Harnett County Government Complex  
307 W. Cornelius Harnett Boulevard  
Lillington, NC 27546

December 19, 2013

**RE: Harnett County Land Use Existing Tank Application # 13-5-32610**

ASBUILT SURVEY

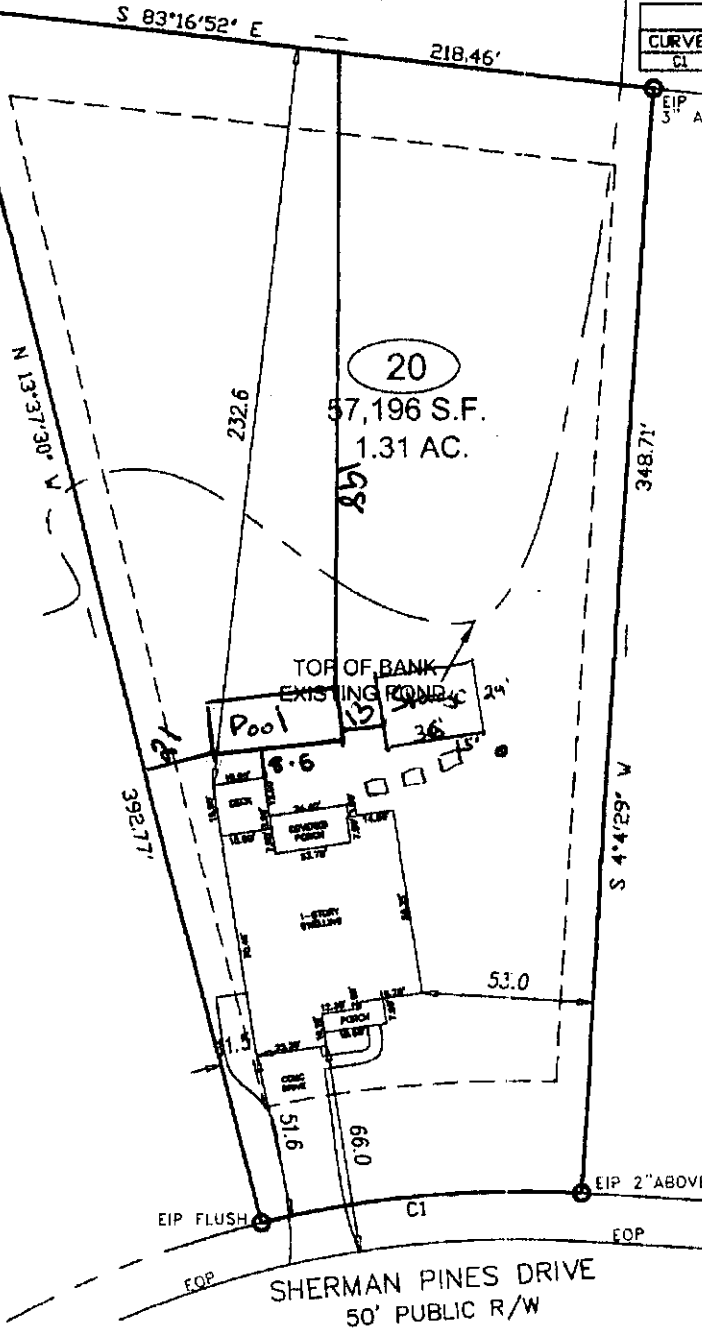
Based on the criteria set out in Title 15A, Subchapter 18A, of the North Carolina Administrative Code, Rules .1950, the evaluation indicated that the site is **UNSUITABLE** for the addition requested. Therefore, your request for an existing tank is **DENIED**. The site is denied based on the following:

- ☒ **15A NCAC 18A.1950a {16} - Any swimming pool must be 15' from any part of septic system. Not enough available space.**
- ☐ **15A NCAC 18.1945{b} - Each lot shall have original septic system plus repair area.**
- ☒ **15A NCAC 18A.1950 {10} - Any building to be 5' from septic tank and/or from drain line. Not enough available space.**
- ☐ **15A NCAC 18A.1950{c} - Nitrification fields and repair areas shall not be located under paved areas or areas subject to vehicular traffic.**
